KITTITAS COUNTY
DEPARTMENT OF PUBLIC WORKS

MEMORANDUM

TO: Noah Goodrich, Staff Planner, Community Development Services
FROM: Randy Carbary, Planner II
DATE: September 26, 2006
SUBJECT: Rogers Short Plat

ROGERS SHORT PLAT
PART OF SECTION 7, T. 19 N., R. 16 E., W.M.
KITKITAS COUNTY, WASHINGTON

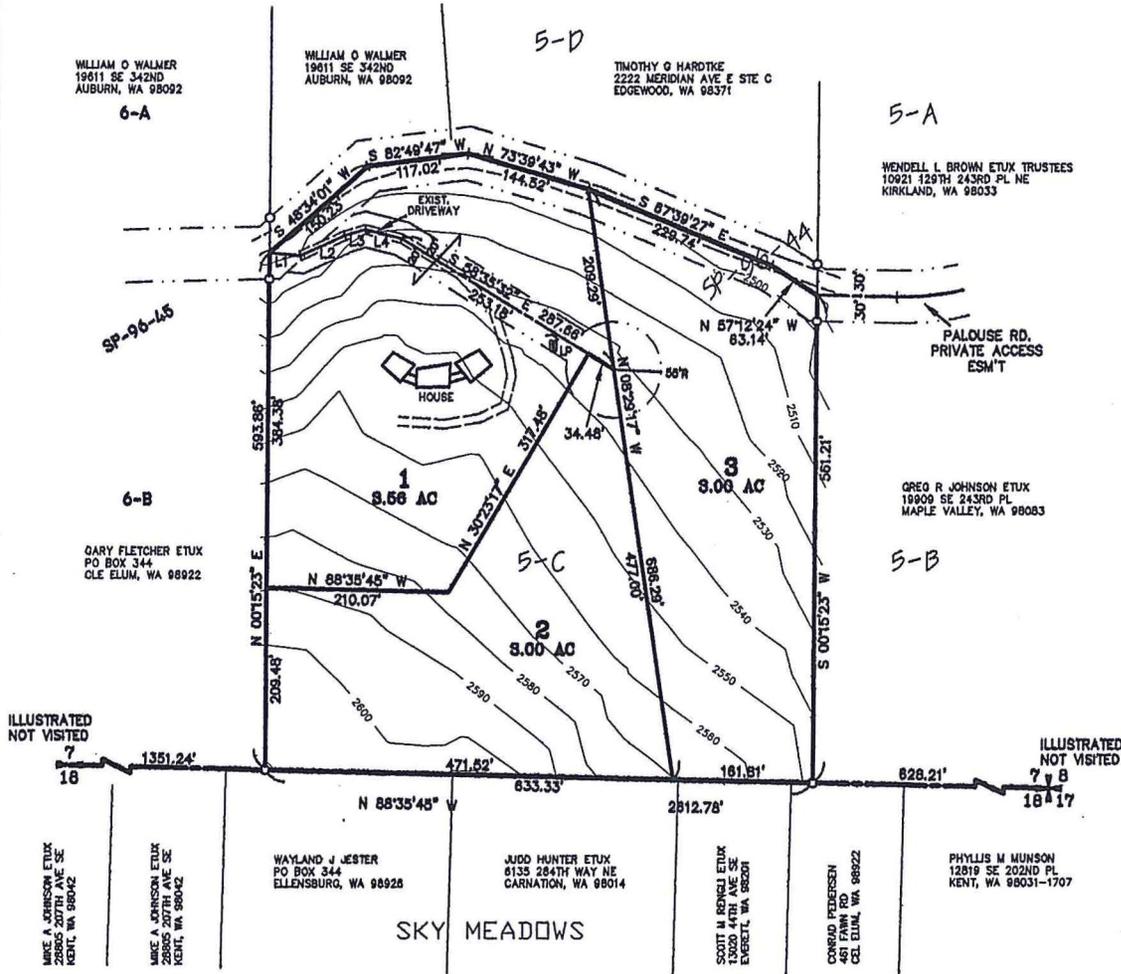
1. Access for Lots 1, 2 and 3: Access for lots 1, 2 and 3 shall be via a 40' access easement as shown on the face of the preliminary plat. Access shall meet or exceed all applicable current Kittitas County Road Standards.
2. Private Road Improvements: Access for lots 1, 2 and 3 shall be constructed as a High-Density Private Road, see current Kittitas County Road Standards.
 - a. Access easements shall be a minimum of 40' as shown on the face of the plat. The roadway width shall be 20', with 1' shoulders = 22' total width.
 - b. All easements shall provide for AASHTO radius at the intersection with a county road.
 - c. Minimum centerline radius shall be 60'.
 - d. Surface requirement is 6" for gravel surface.
 - e. Maximum grade is 8% flat, or 12% rolling or mountainous.
 - f. Stopping site distance, reference AASHTO.
 - g. Entering site distance, reference AASHTO.

3. Access Easement Private Road: The construction of the new private road within the 40' access easement shall be inspected and certified by a licensed professional engineer for conformance with the current Kittitas County Road Standards. Kittitas County Public Works shall require this road certification to be completed, prior to the issuance of a building permit for any of the residence within the proposed short plat.

5. Intersection of Proposed Access: The newly proposed access road serving lots 1, 2 and 3 shall meet all applicable standards for alignment.
6. Plat Notes: The following shall be added as plat notes: Entire Private Road shall achieve 95% compaction and shall be inspected and certified by a licensed engineer in the State of Washington specifying that the road meets current Kittitas County Road Standards prior to the issuance of building permit for this Plat. **Plat Note.**

- Any further subdivision or lots to be served by proposed access may result in further access requirements. See Kittitas County Road Standards.
- All ingress/egress and utility easements shall have the AFN (Auditors Recording Number) on the face of the plat. **Update Plat.**
